Our ref: AN/2025/137223/01-L01
Your ref: H16-1073-25
Date: 27 November 2025

**Proposed self build dwelling
Land Adj 26 Stonegate Spalding Lincolnshire PE11 2PH**

DRAWING No.
 116 P02

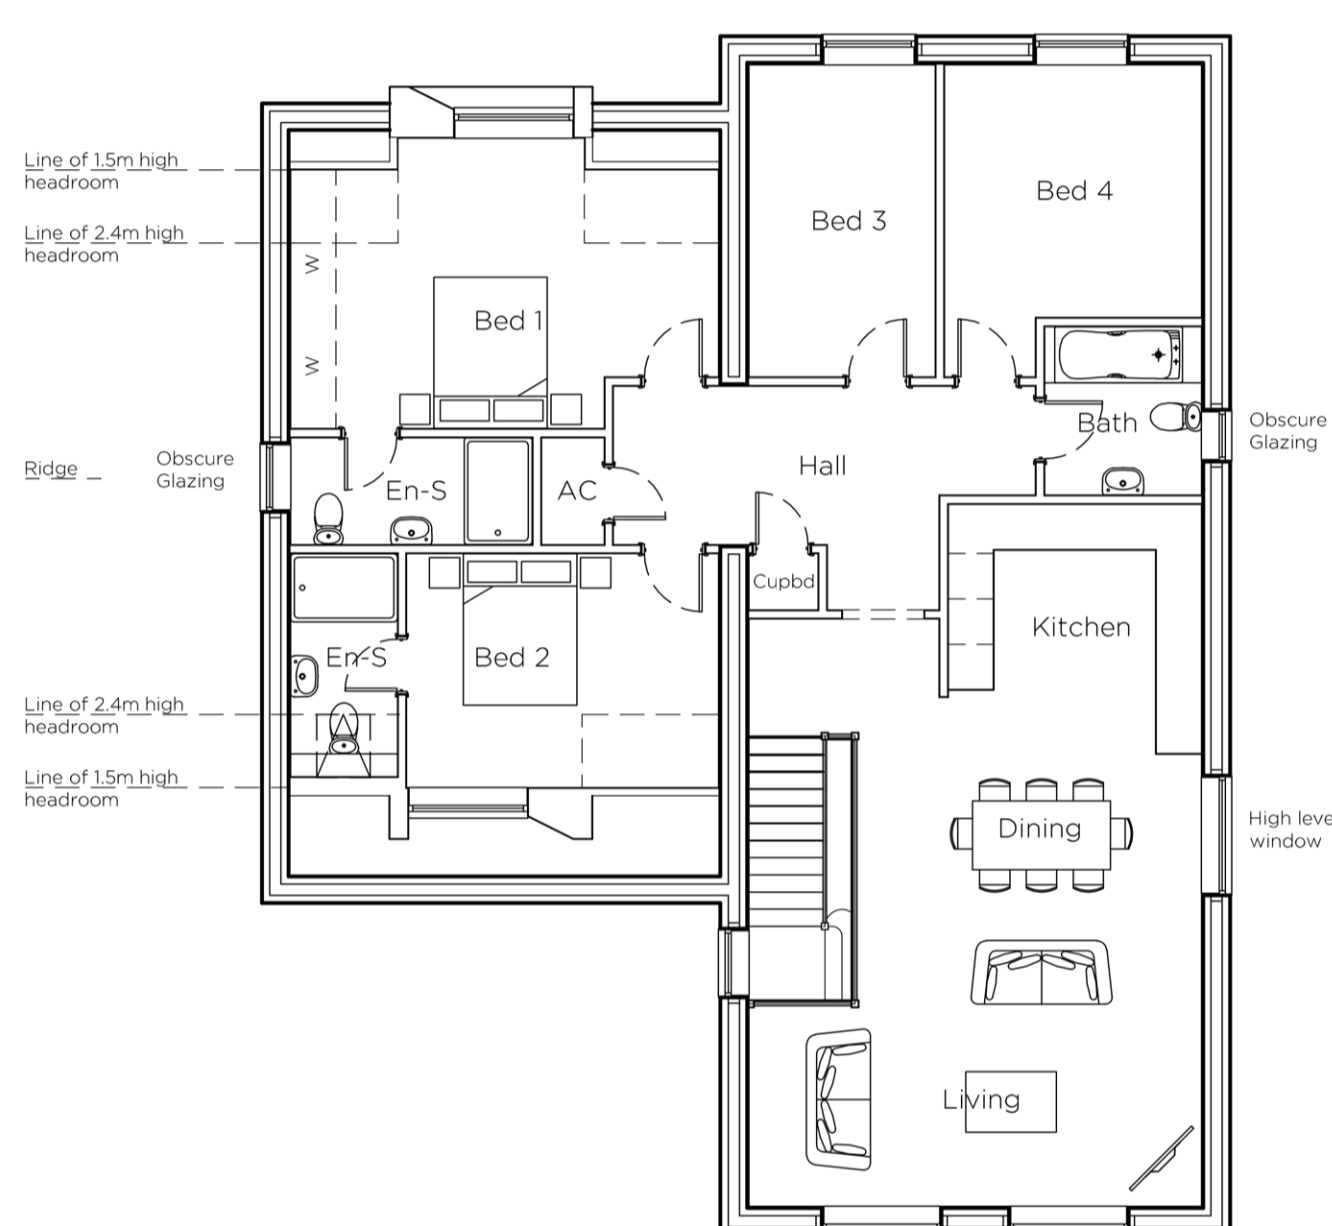
The ground floor of the dwelling hereby approved shall be used as garage, WC, store, hall, boot room, garage and utility only and as annotated on approved drawing 116 P02; dated August 2025; submitted by Seven22 Architecture LTD, and for no other habitable accommodation.

In accordance with the details of the application and to ensure that there is no sleeping or vulnerable living accommodation on the ground floor, in order to protect the inhabitants of the property from the risk of flooding in accordance with Policy 4 of the South Lincolnshire Local plan 2011-2036.
